Subject: Planning Application 2023/91212 Erection of 21 dwellings to the West of Bankfield Drive , Holmbridge

I would like to object to this Planning Application on the grounds of Insufficient Technical Information regarding Water Drainage.

TITLE
S104 DRAINAGE LAYOUT PLAN

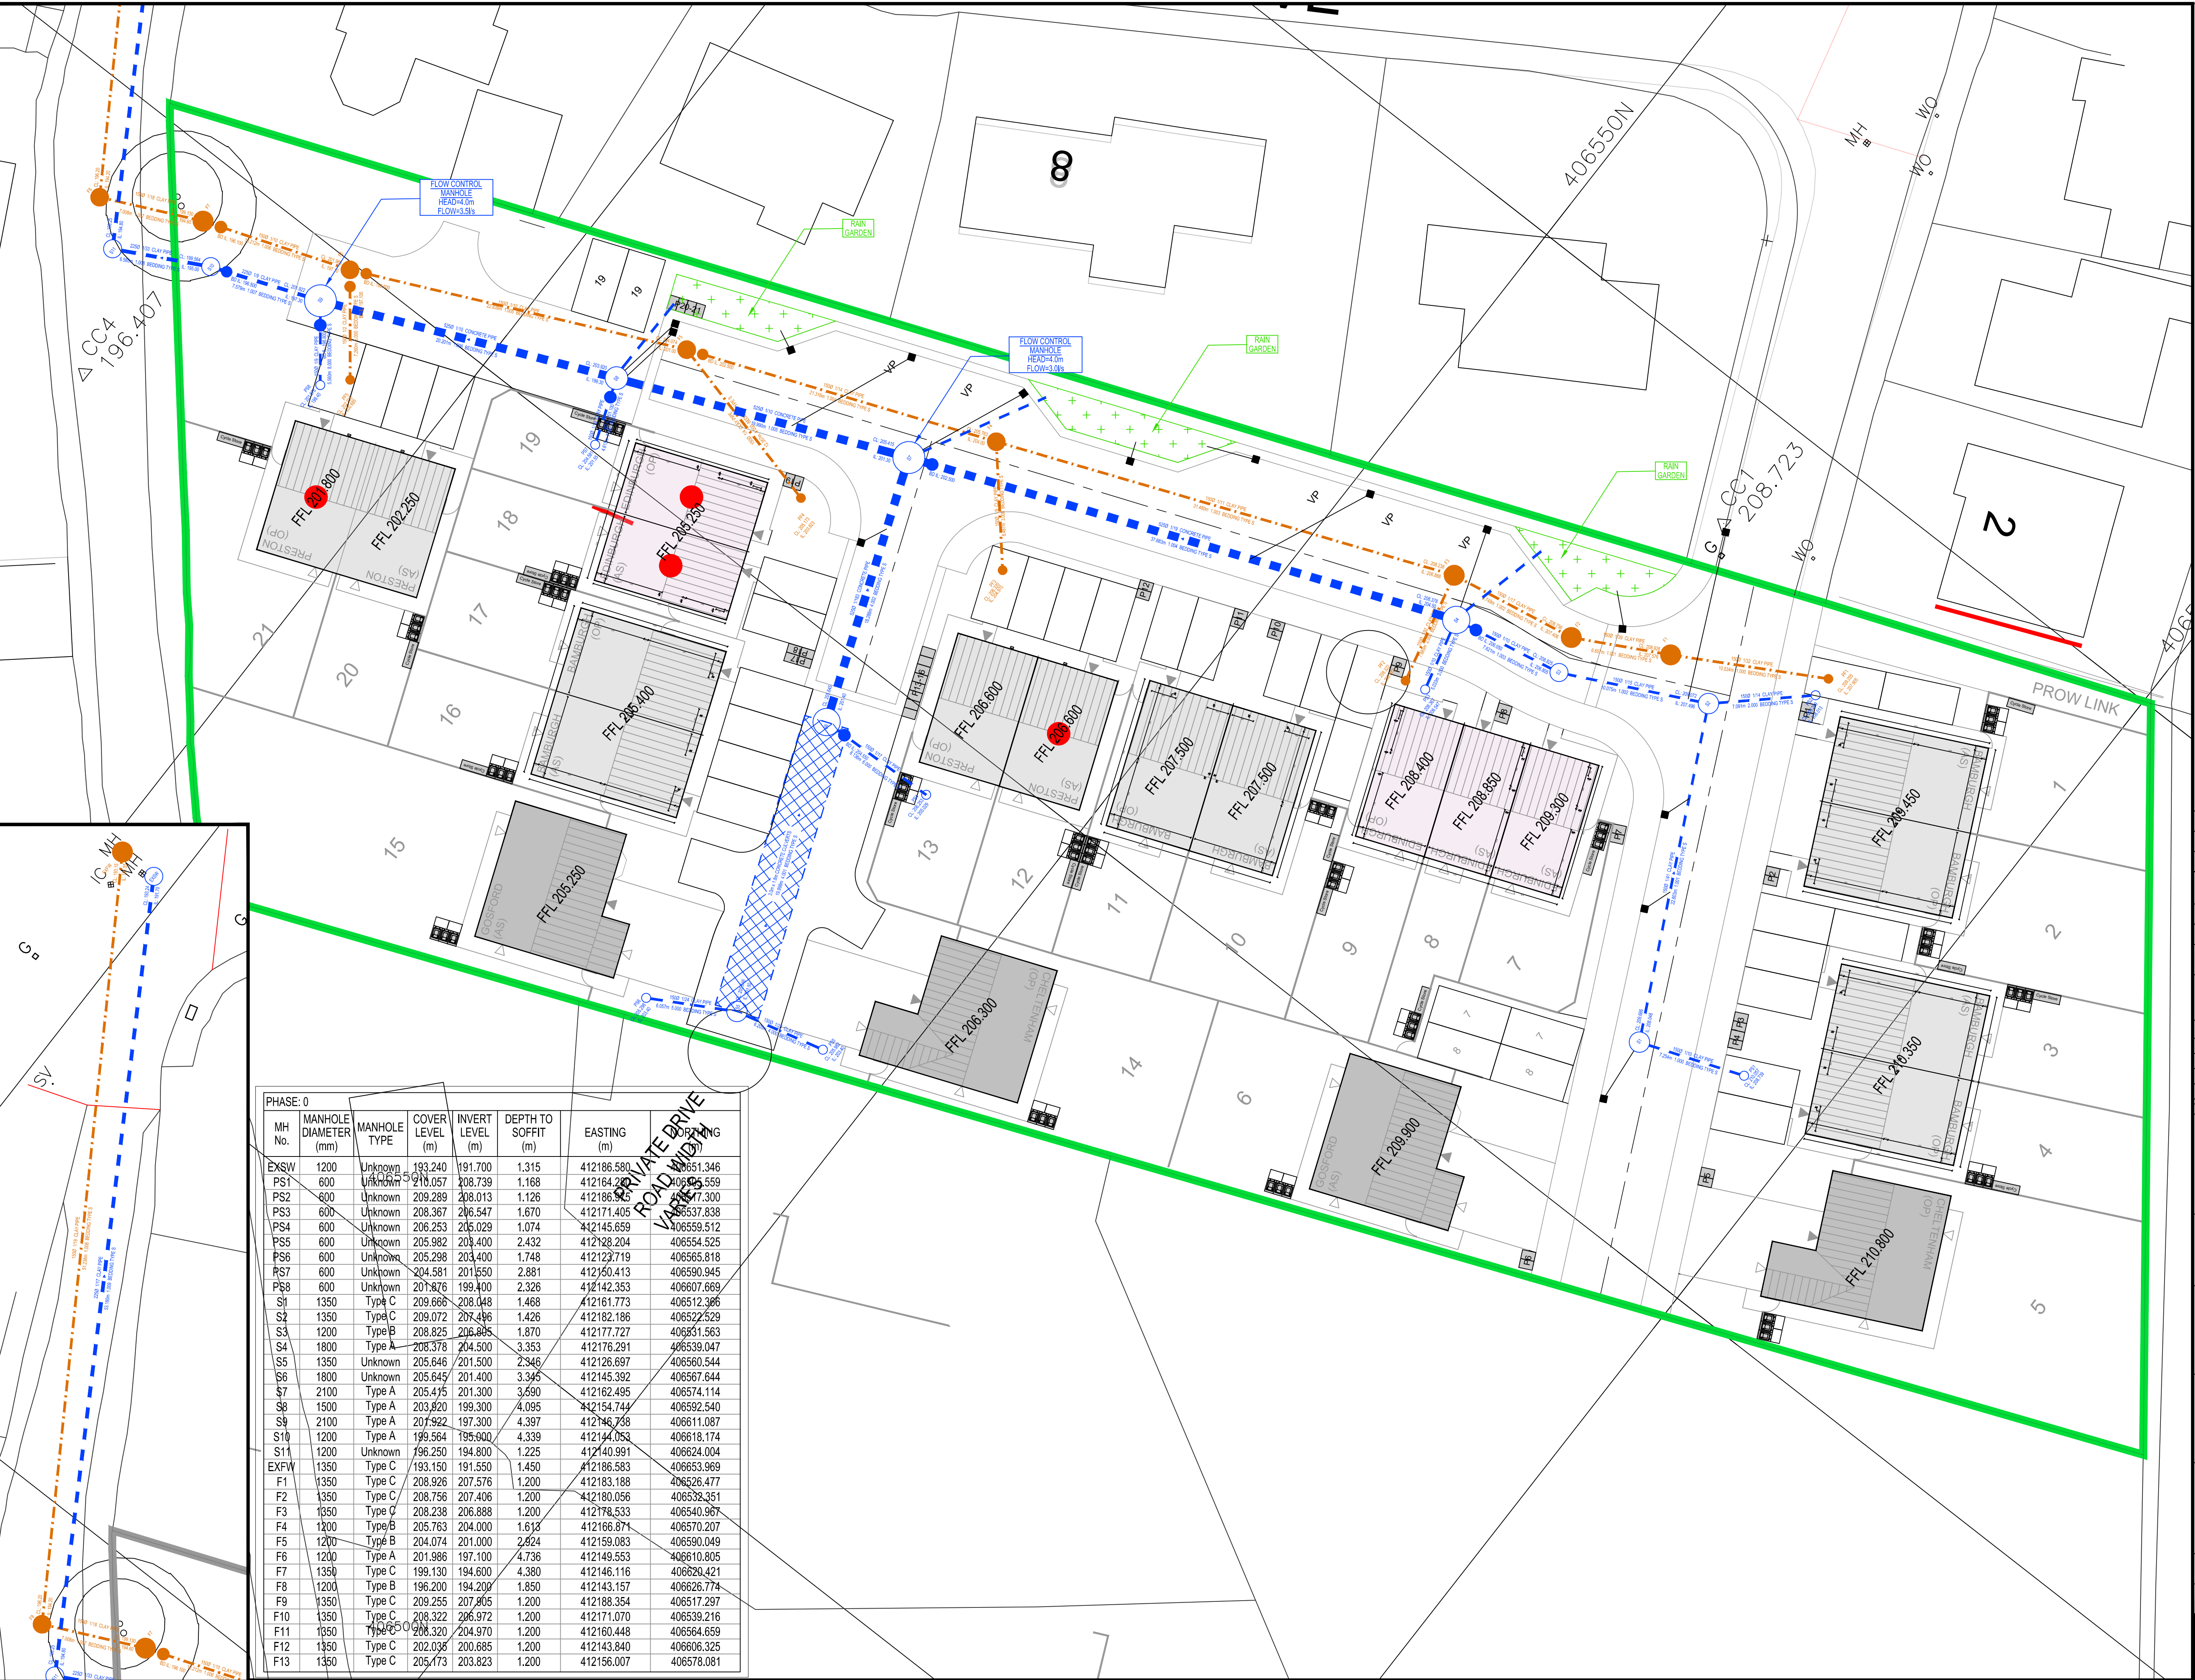
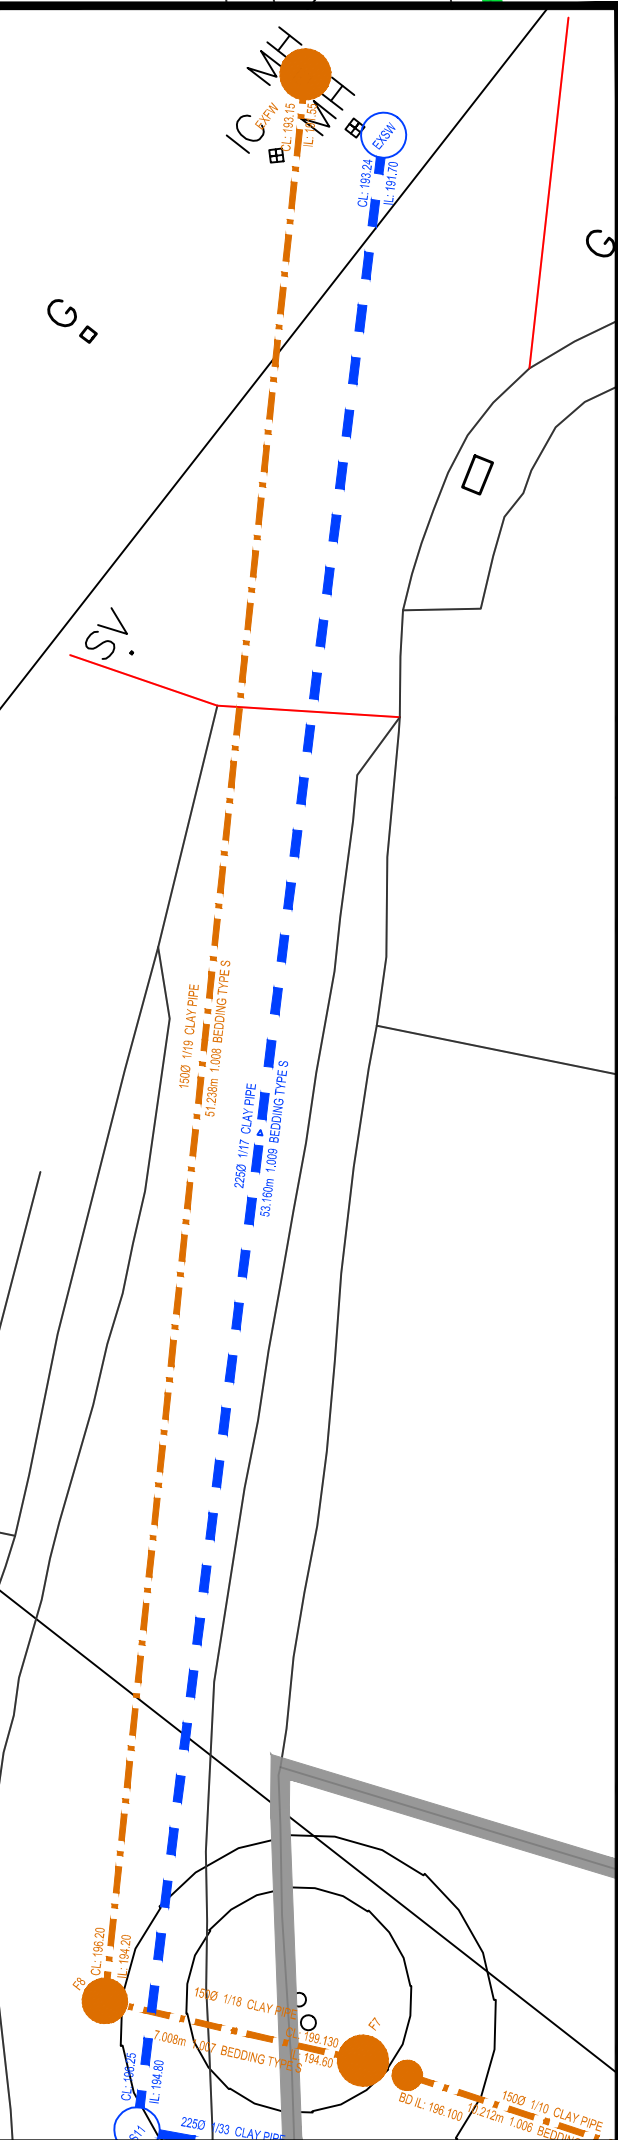
5. Site HS183 frequently floods , presumably due to natural spring water plus extra surface water from higher fields to the South. (Ducks have been seen swimming on the ponds formed on this site.) . Current plans do not show any methods for diverting this EXTRA water from reaching Site HS183
